Freezer Drawing for City Line Dr Project

In looking over the prefab freezer information, I have a couple of questions/comments:

City of Portland Mail - Freezer Drawing for City Line Dr Project

Freezer Dimensions

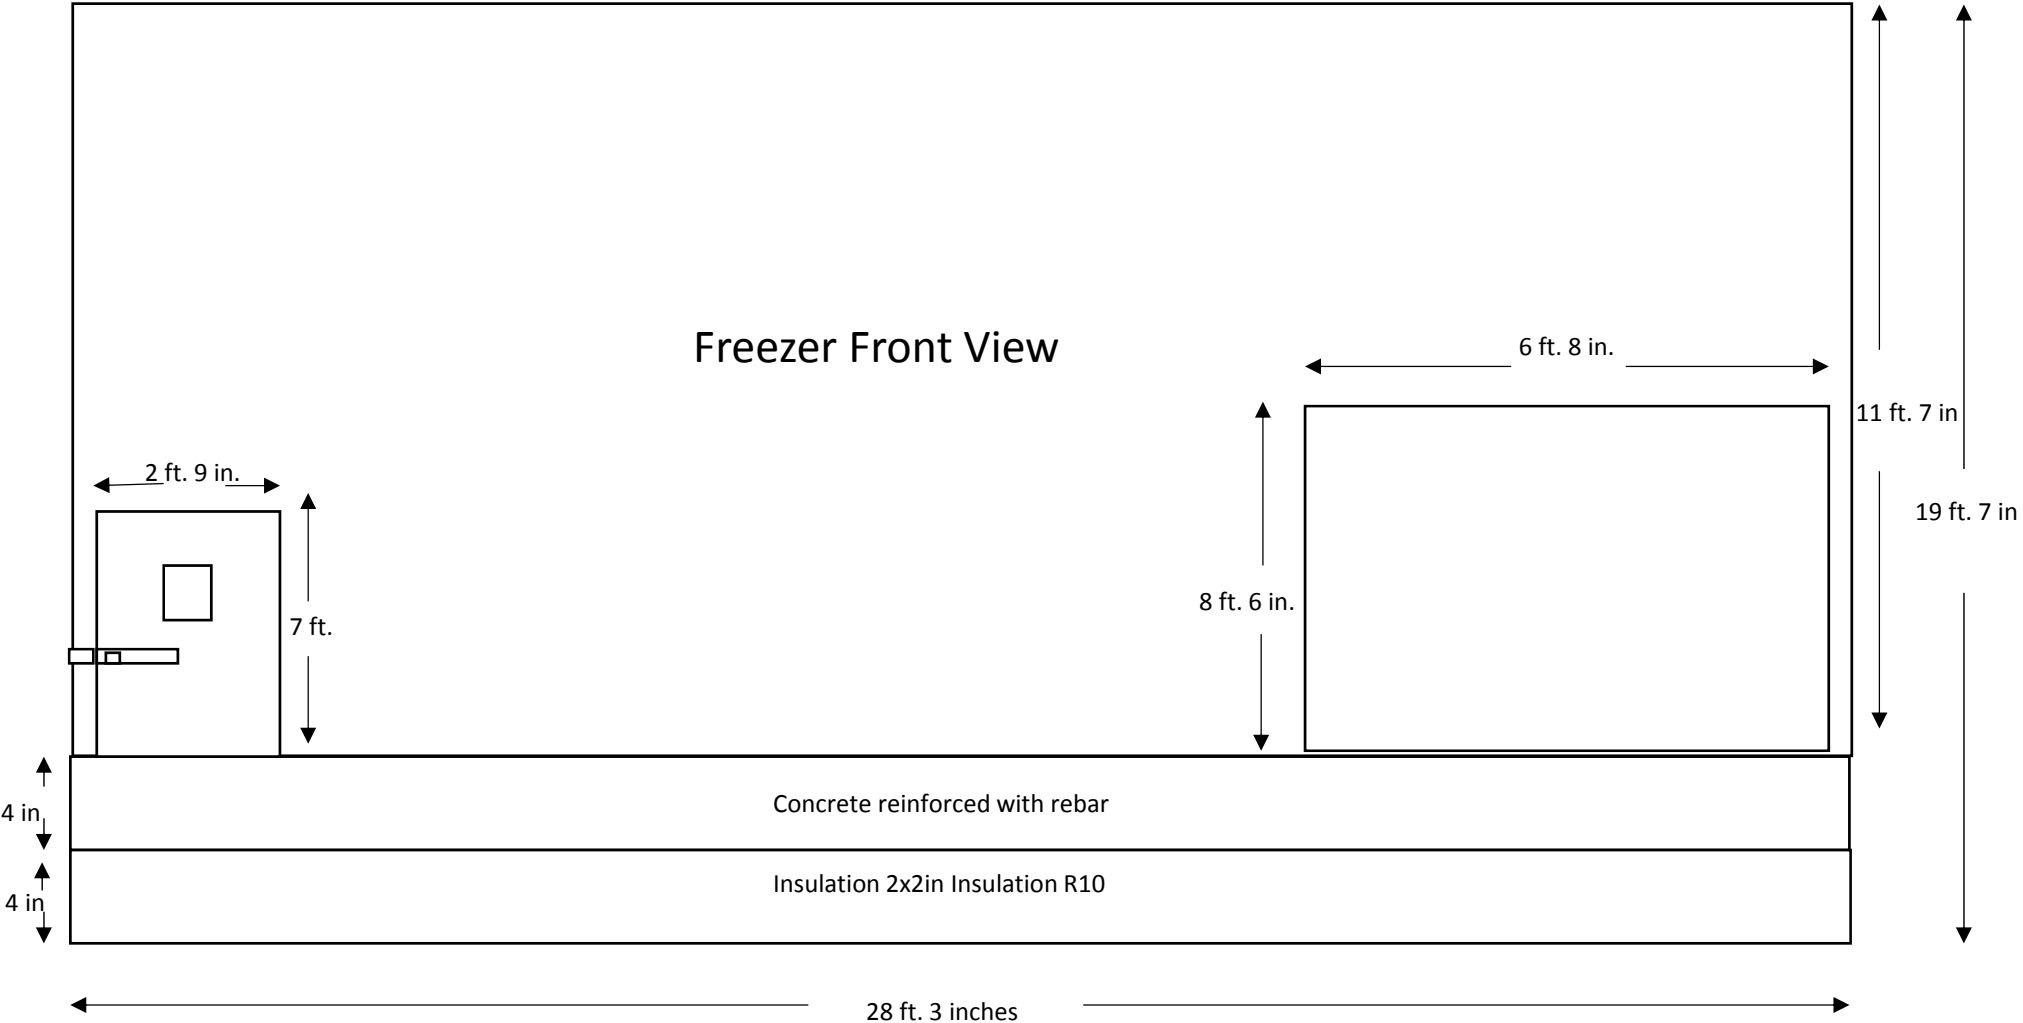
1. What is the width of the of structure?
2. Per NFPA, the sprinkler system will need to be extended into this structure, please confirm.

- 1) The width of the structure is 24 feet wide.
- 2) Yes, Eastern Fire will be installing a sprinkler in the structure.
